LIBERTY TREE ACADEMY - PHASE 2 CONSTRUCTION DOCUMENTS

LIBERTY TREE ACADEMY - PHASE 2
TOWN OF PEYTON, EL PASO COUNTY
CONSTRUCTION DOCUMENTS, PCD FILE NO. PPR-20-XXX

TITLE SHEET
Add PCD File #

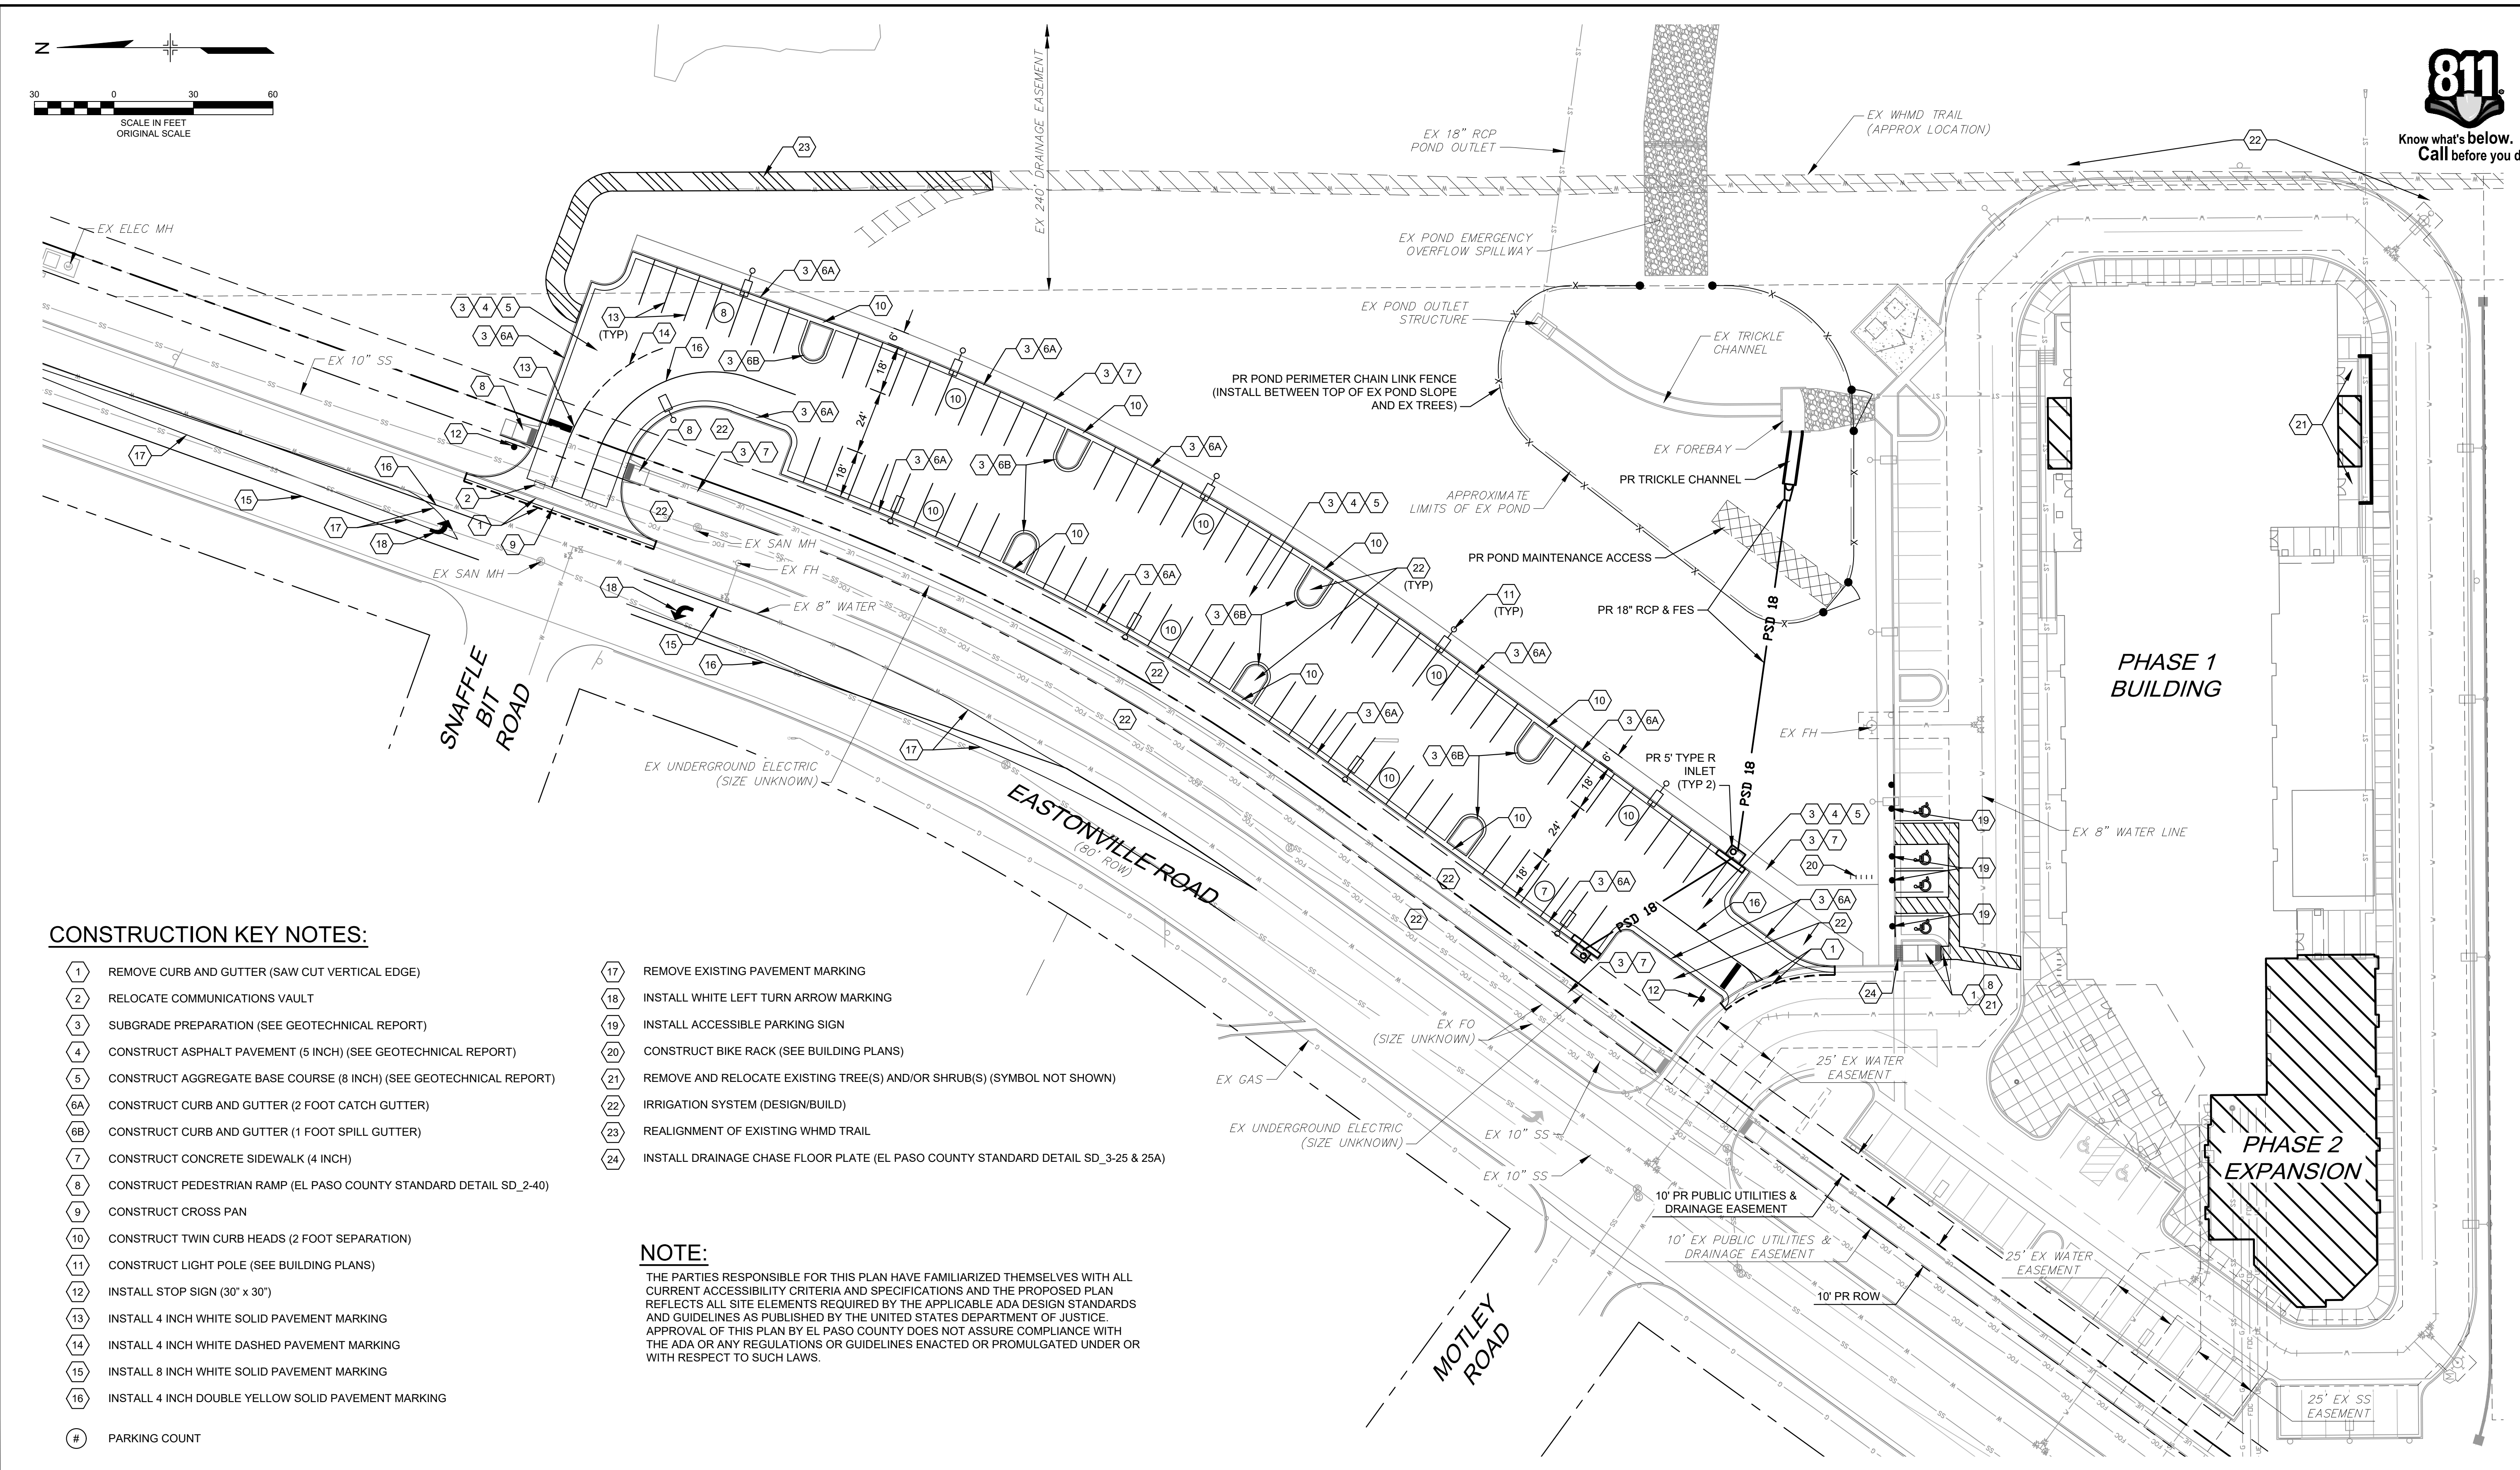
Please verify the EFC stamped PED (ump seal)

The EFC stamp is required for a minor aerial deviation request form for this additional access point.

GRADING PLAN  
EPC 9/23/2020

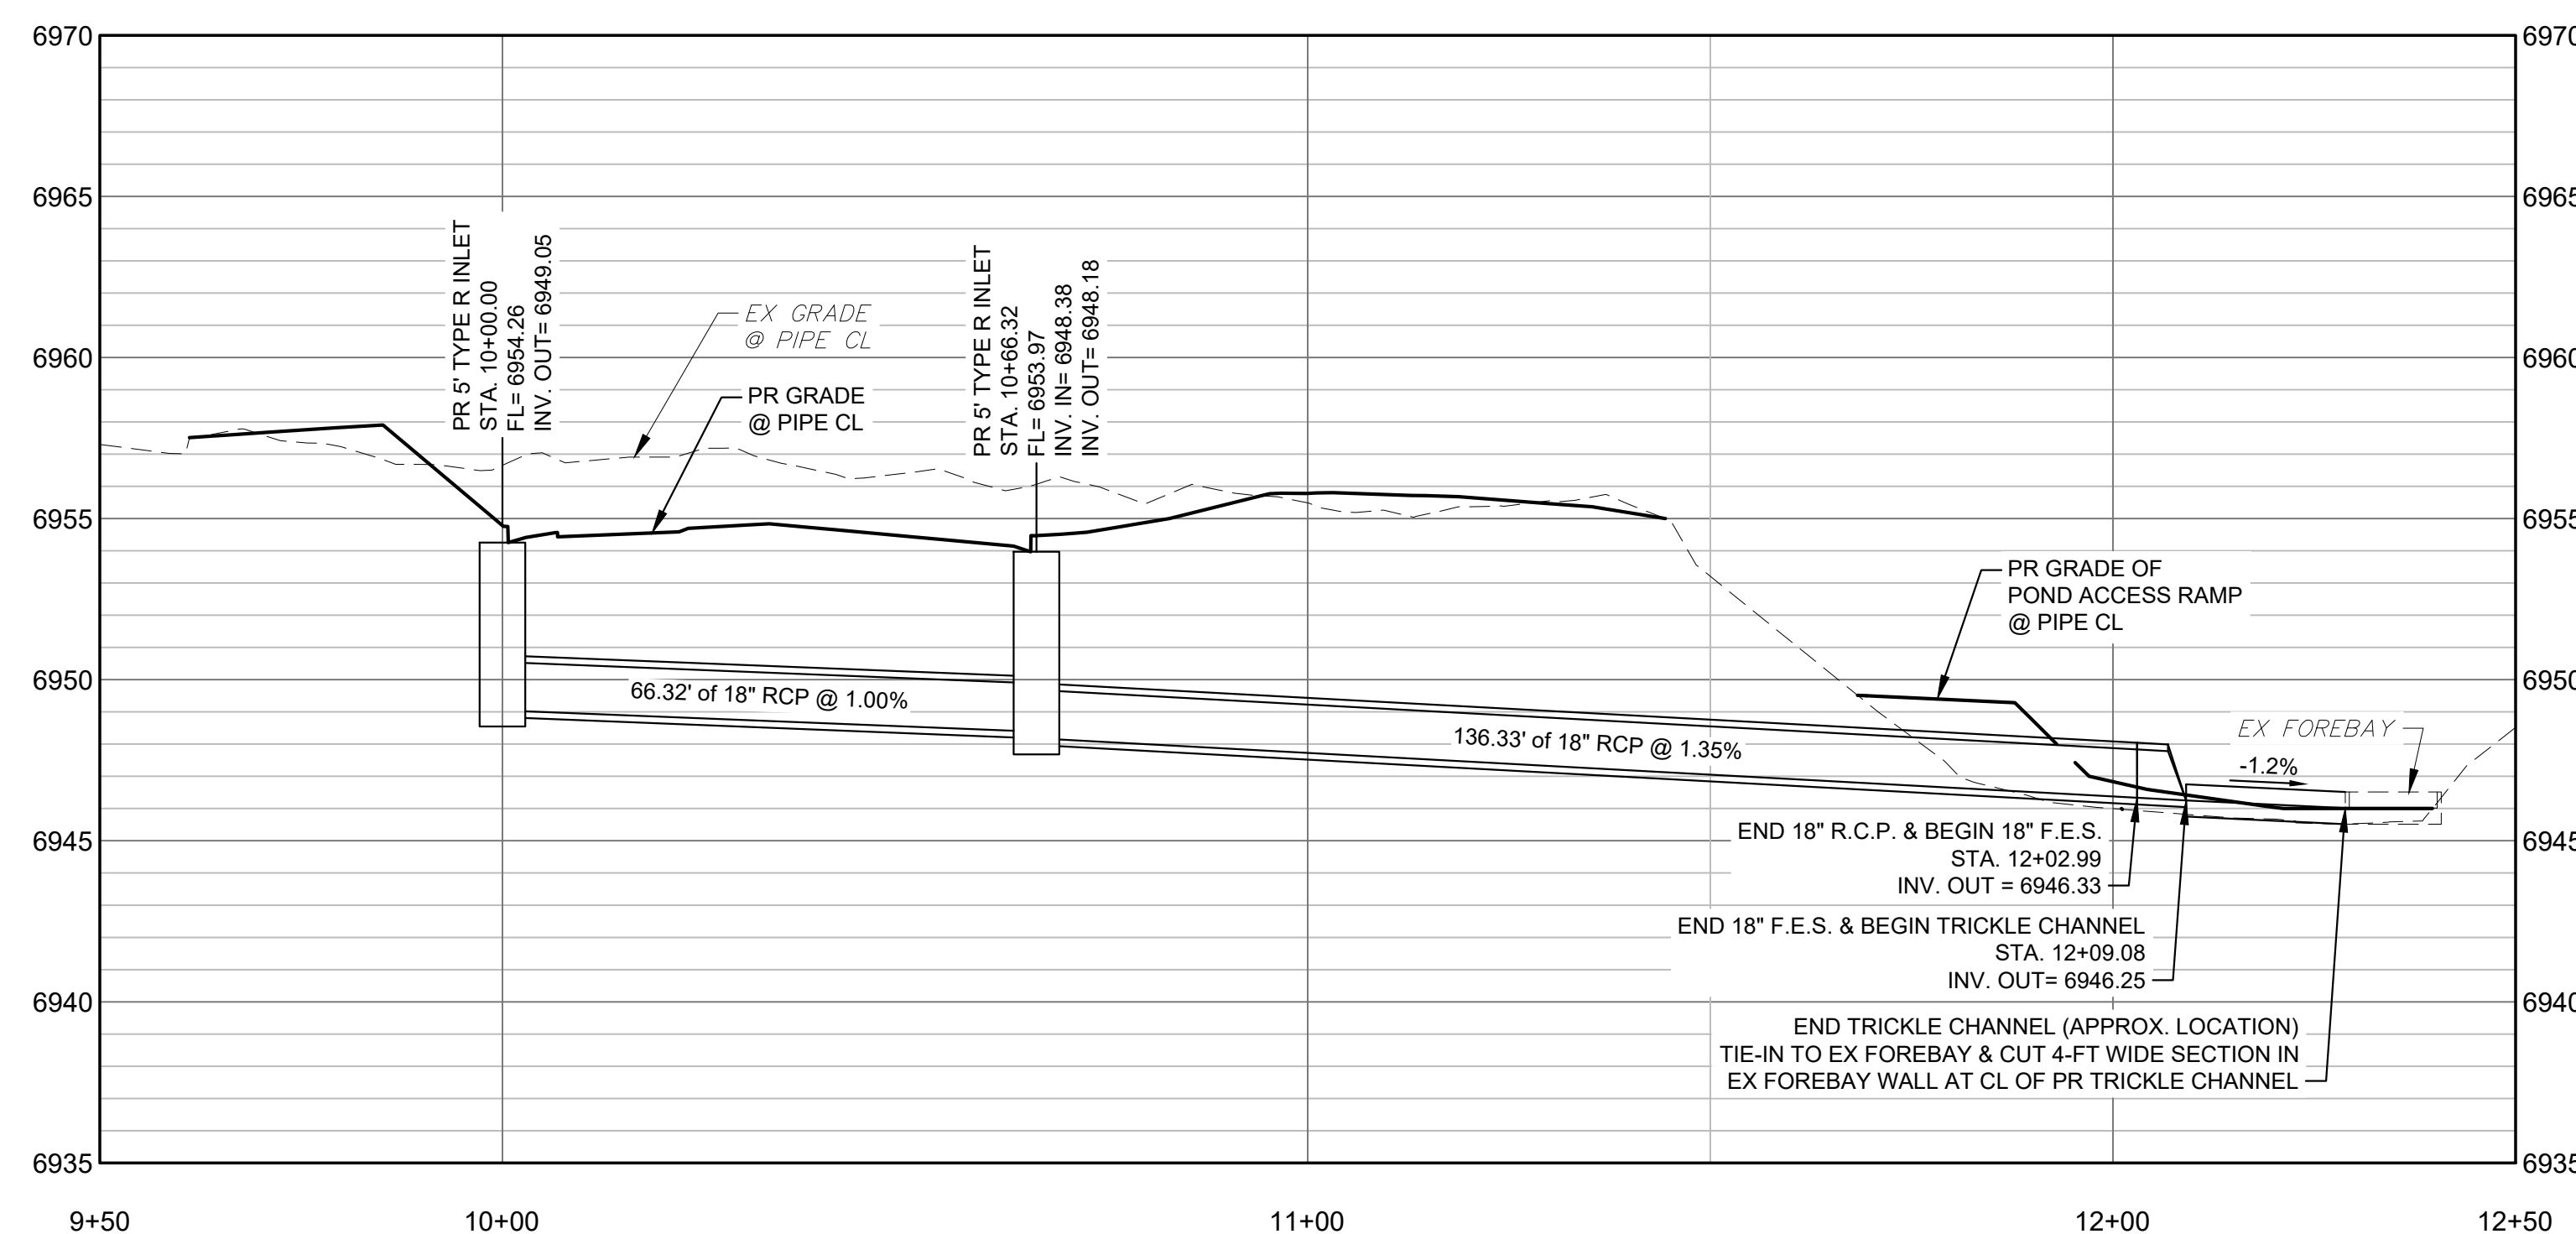
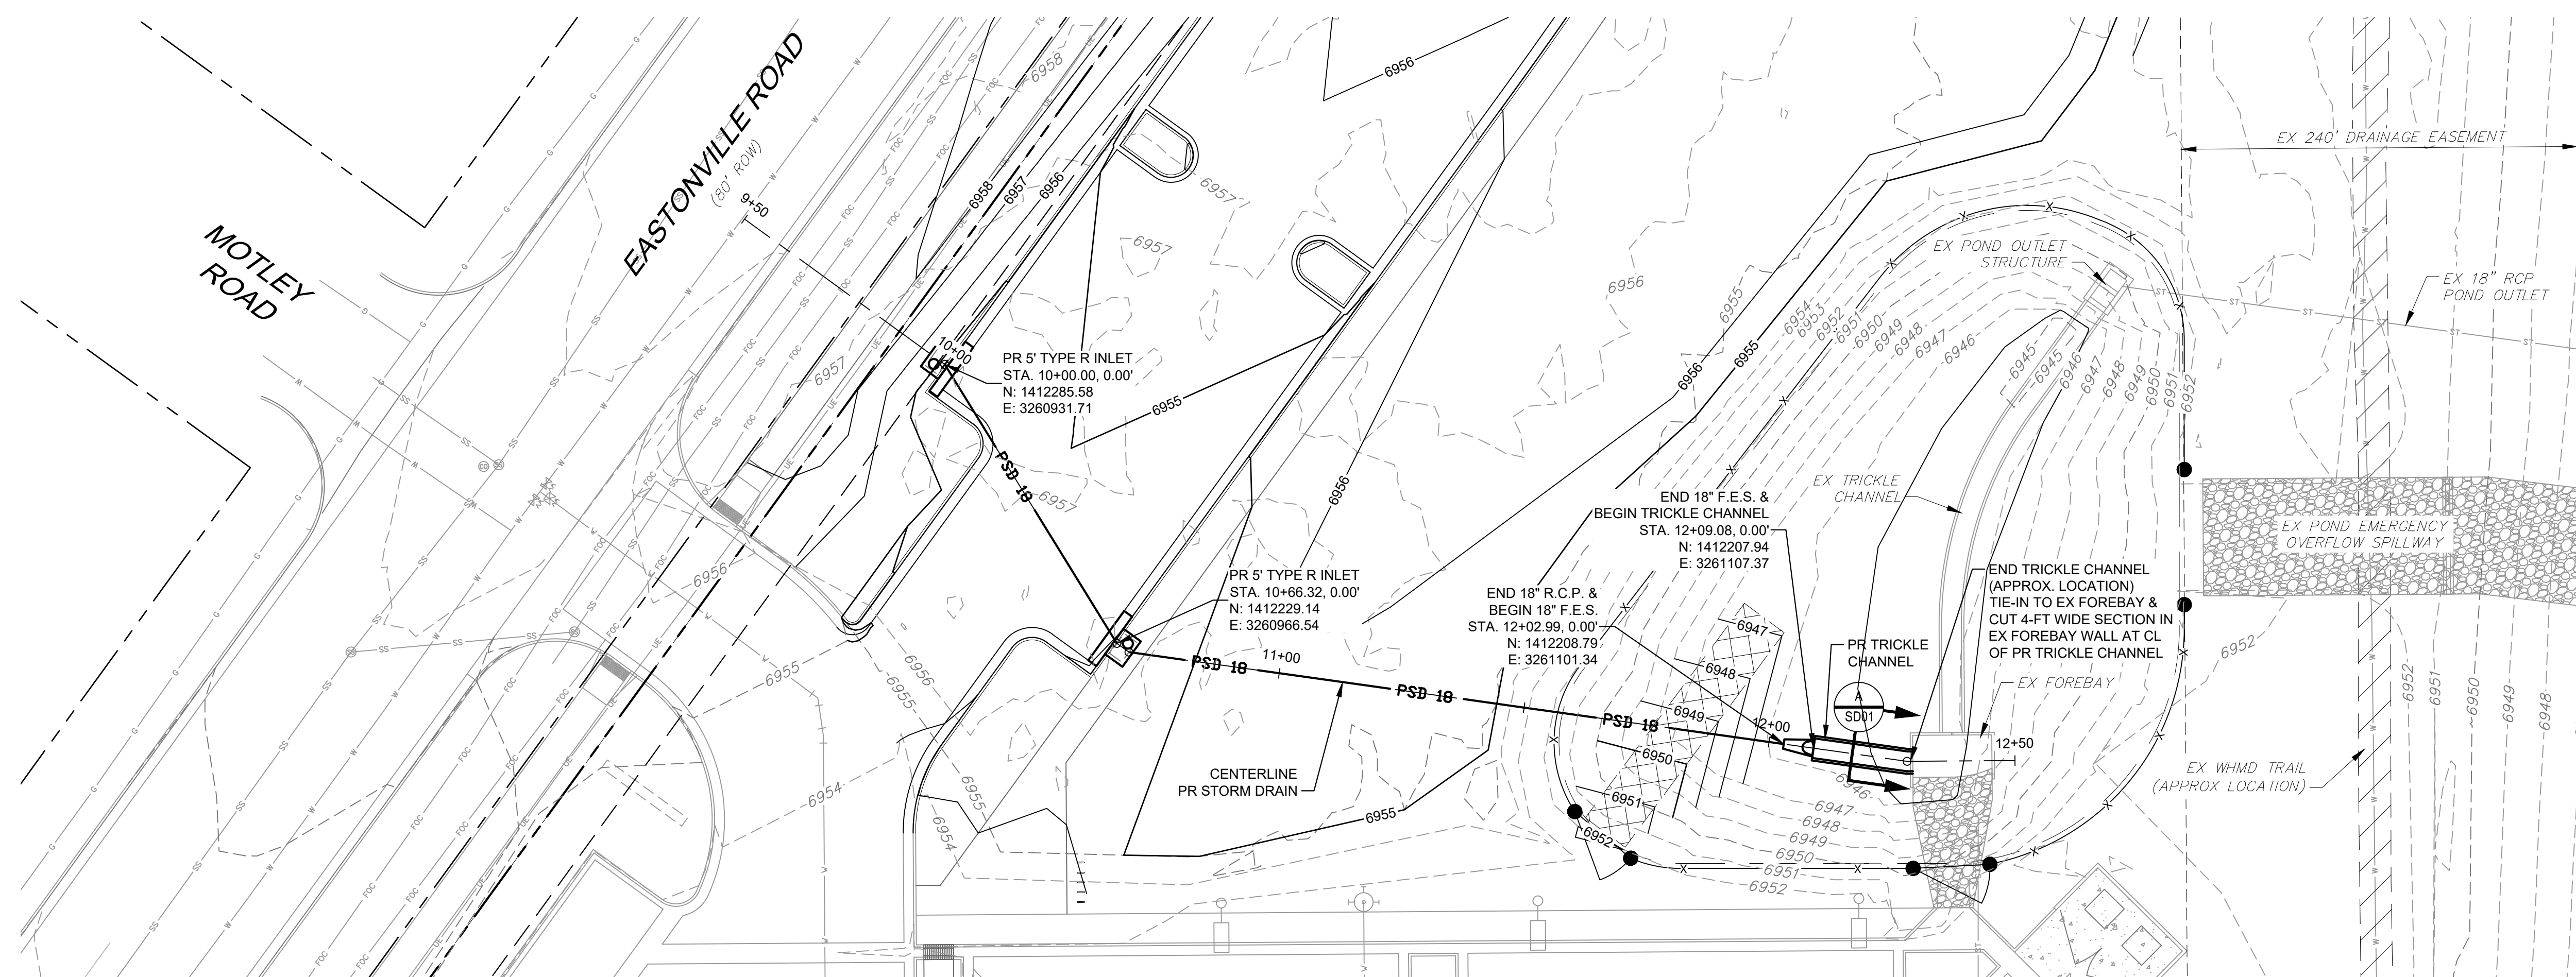
If any changes are required to the as-built details of those changes shall be provided.
